RE: 6/2020/3439/COND– Northaw House, Coopers Lane, Northaw, Potters Bar, EN6 4NG

Thank you for consulting us on the above application for the submission of details pursuant to condition 1 (surface water drainage scheme) on planning permission 6/2019/0217/MAJ at Northaw House, Coopers Lane, Northaw, Potters Bar, EN6 4NG.

We advise the LPA that the information submitted in support of condition 1 in relation to surface water does not comply with the requirements of the condition. Therefore, we recommend that the LPA does not discharge condition 1.

DRAWING TITLE: **PROPOSED POND SECTIONS**

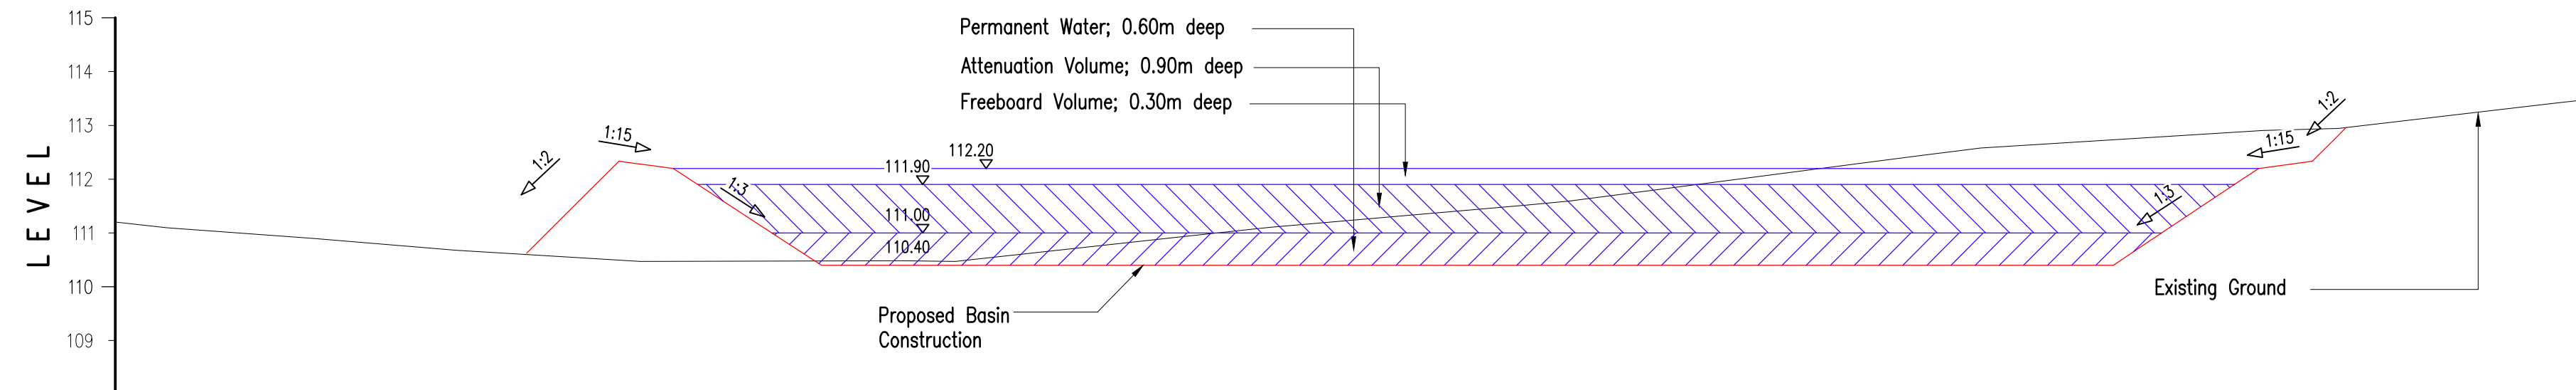
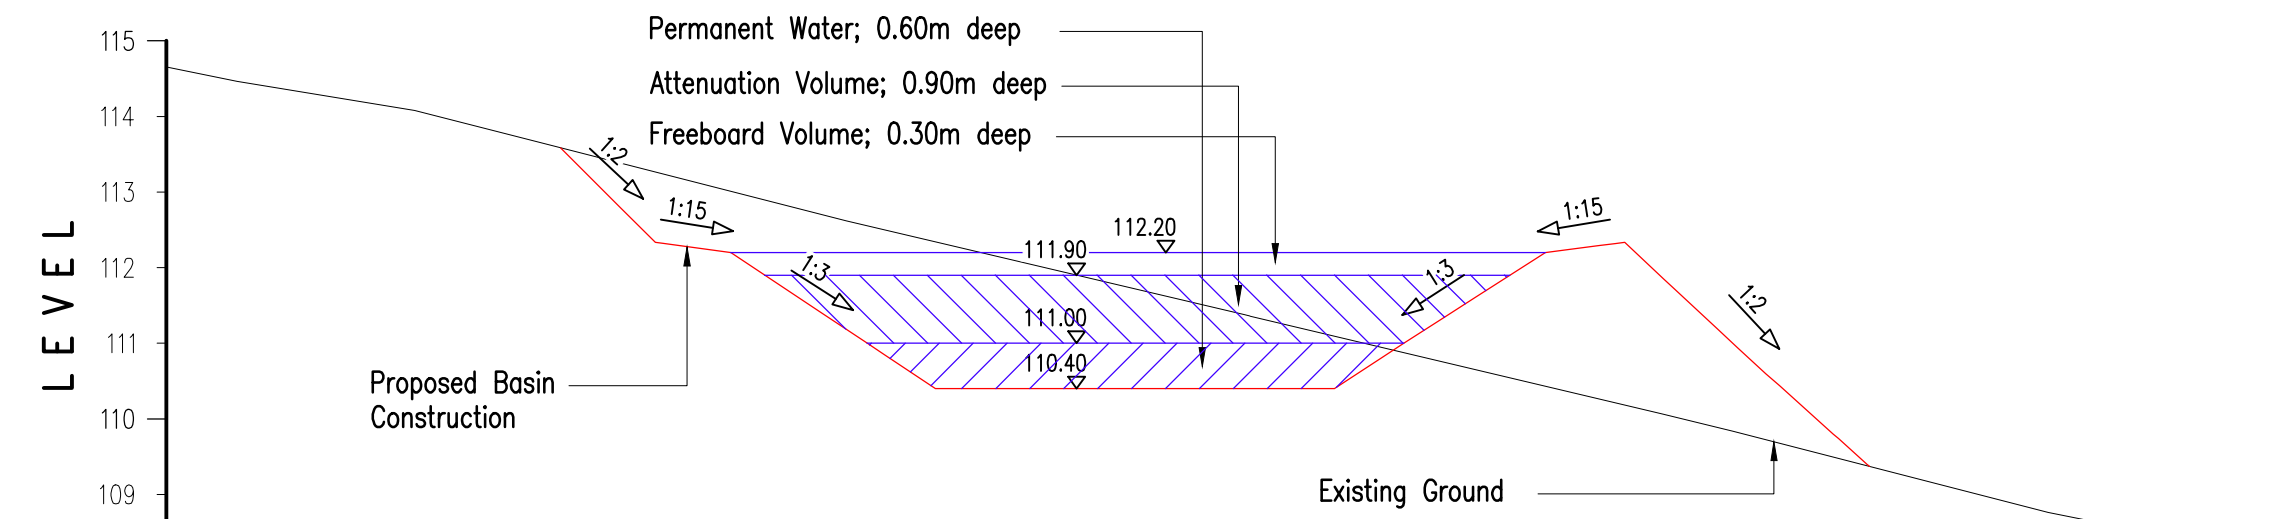
The applicant has provided calculations for the 1 in 100 year + 40% climate change event and confirms that the basin size has been increased to provide a total volume of 1305 m³. The applicant has provided post-development network calculations including half drain down times indicating the basin will take approximately 27.13 hours to drain down to half during the 1 in 100 year + 40% climate change event.

However, as per our responses to 6/2020/1181/COND, we require half drain down times to be less than 24 hours or evidence that the proposed network can manage for a 1 in 100 + 40% climate change storm followed by a 1 in 30 year event.
